## A303 Sparkford to Ilchester Dualling Scheme TR010036

### 8.4 Statement of Common Ground with Somerset County Council and South Somerset District Council

**STATEMENT OF COMMON GROUND**

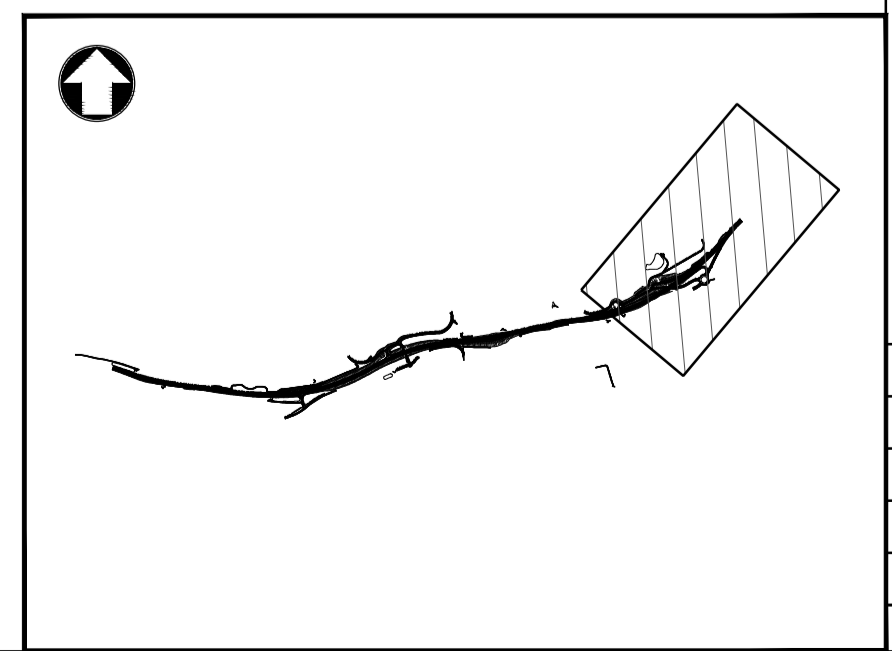
Lighting	Responsibility for proposed system of lighting at Hazlegrove Roundabout is yet to be resolved, although SCC's view at this time is that Highways England would retain maintenance responsibility.	Noted, although this is a detailed design point and so the Applicant is not in a position to agree this at stage.	<b>NOT AGREED</b>
Drainage	Detailed drainage proposals confirming that only surface water runoff from the local highway network discharges to Pond 4 will need to be submitted before SCC are able to accept maintenance responsibility for this pond.	Highways England have confirmed that they will be the maintaining authority for all ponds proposed as a result of the scheme.	<b>AGREED</b>
	Further consideration of alternative drainage features that reduce the maintenance burden on the adopting authority is required.	The dDCO provides at Requirement 13 that the detailed design will be submitted to the Secretary of State for approval following consultation with the relevant planning authority and local highway	<b>NOT AGREED</b>
